Wells Fargo  
3001 78TH Ave SE  
Mercer Island, WA 98040  
Permit: DSR24-007

Corrections Response.

**SECTION VIEW**  
 SCALE: 3" = 1'-0"

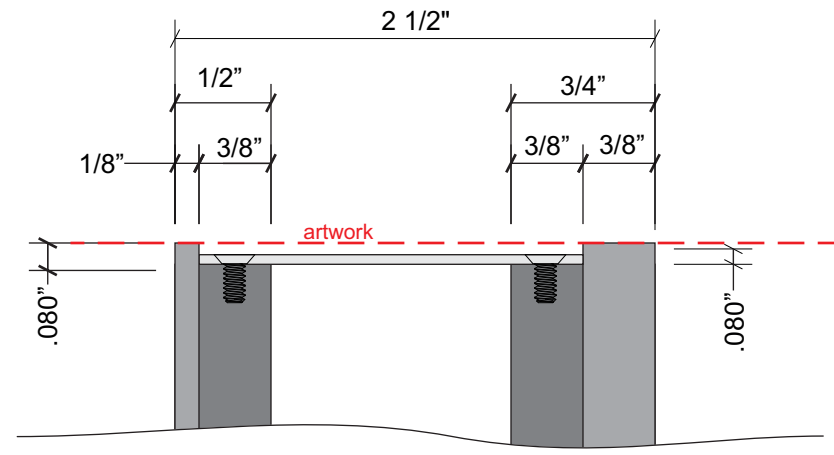
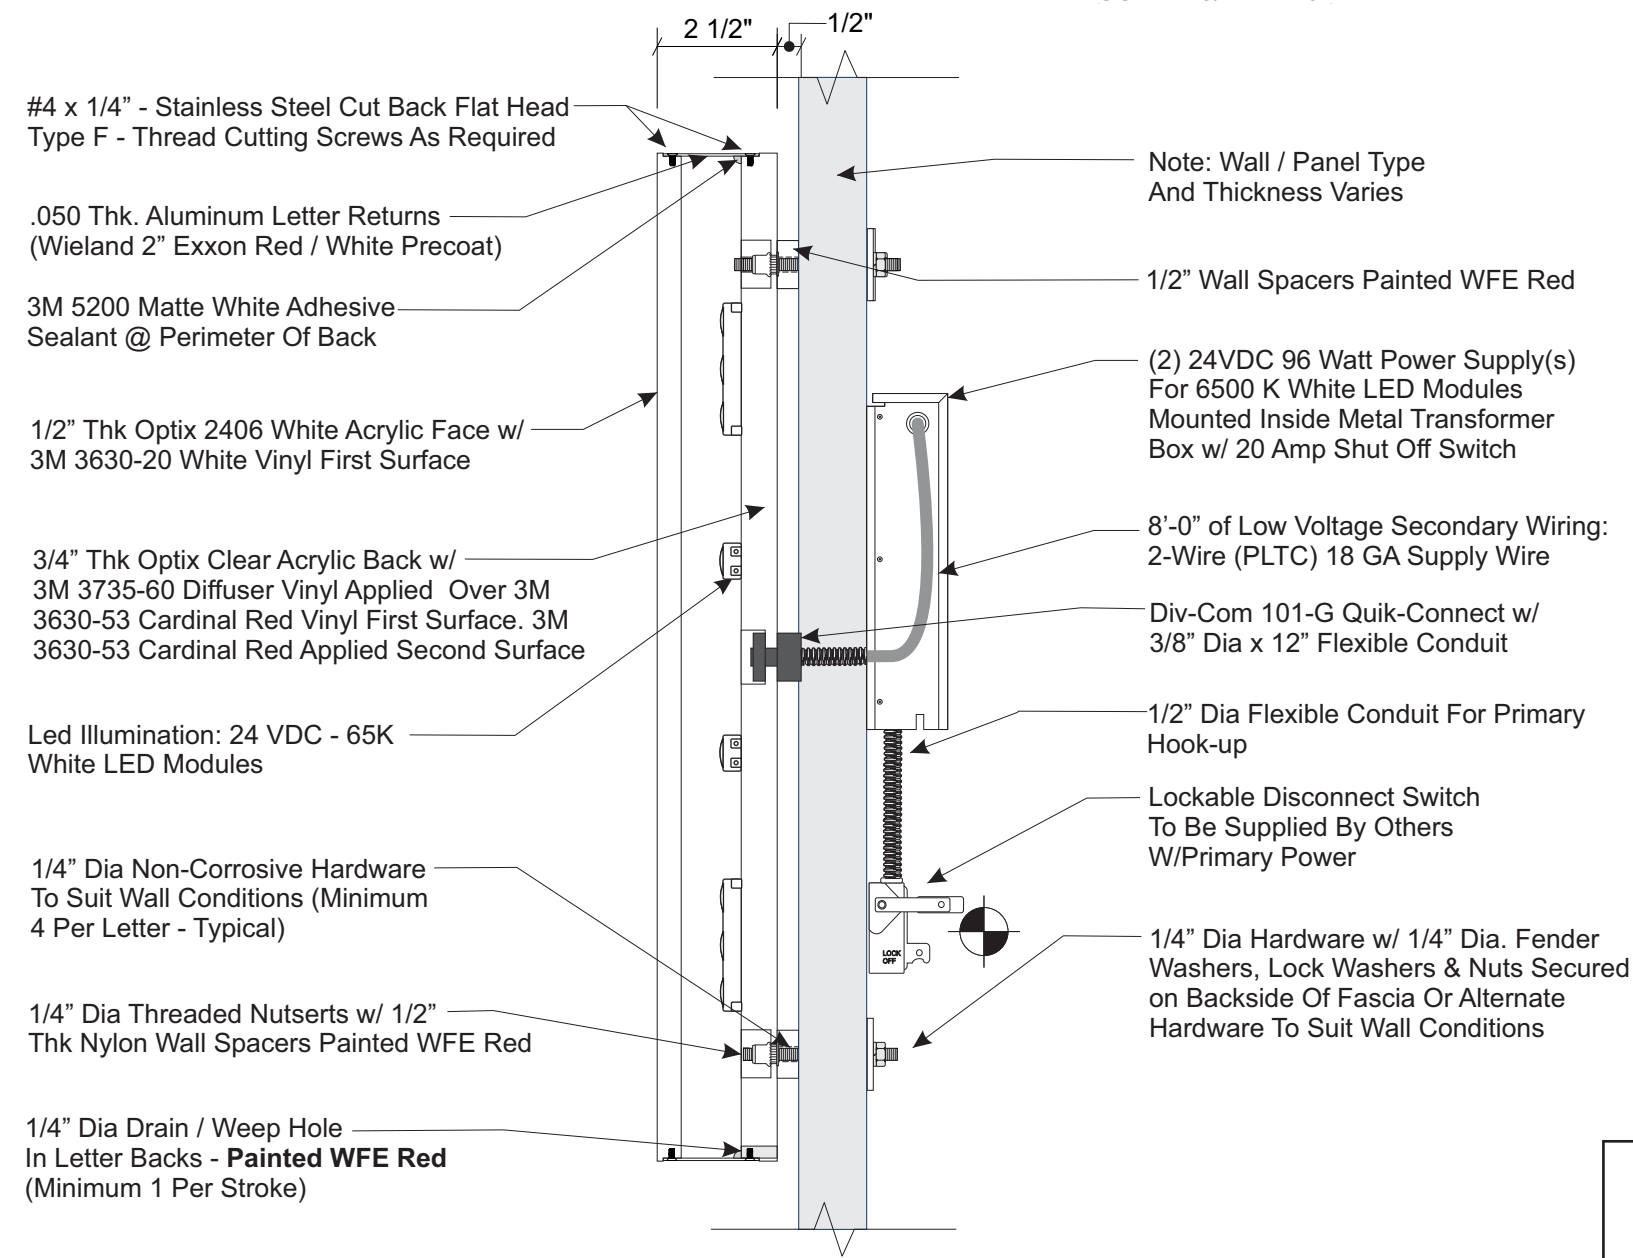
### **Building**

Response: hardware details added to the plans.
